Sub : C.M.C. - Area Plans Unit - Planning Permission for the proposed construction of multi storey office residential building with flats/ studio units at New Door No.15, North Main Street, Sri Nagar Colony, Webberapetam Village, T.S.R.D., Block No.4 of Nethralam Ward - Application - Submission of development sketches - Requested regarding-

The Planning permission application and revised Plan received in the reference has cited for the proposed construction of stilt floor + 4 floors residential building with 6nos of dwelling units at New Road No.13, North Main Street, Sri Nagar colony, Vellorepetam village, V.O.Halli-36, Block No.4 of Hassanah Colony Taluk Channal as under mentions.

RAIN WATER TRENCH  
SCALE - 1:50

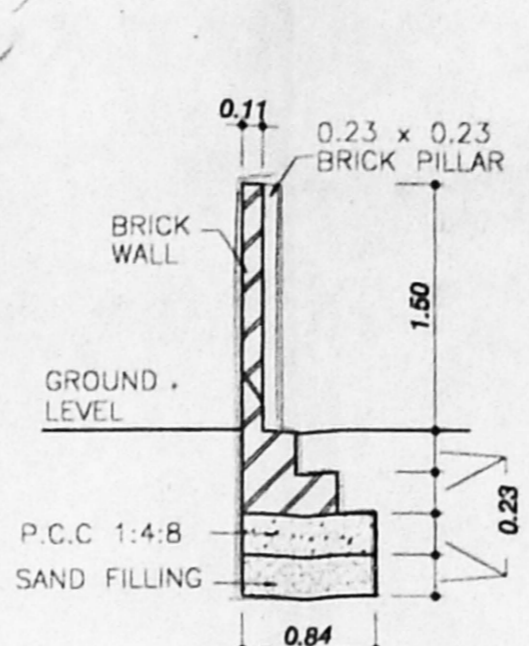
- Revised copy of sanctioned possession plan of Chennai Corporation duly attested by Notary public.
- Revised general power of attorney deed issued by applicant by giving the specific power for applying for planning permission to CMA.
- Revised plan showing the current no in the title of drawing, revised car parking arrangements to be shown in multi floor by complying the driveway, turning radiuses as per Development Control rules.
- In the site plan the word "Multi floor can site plan" to be struck instead of "Ground floors can site plan".
- Roof wall details to be shown at the entrance & Exist Gates for Rain water harvesting.
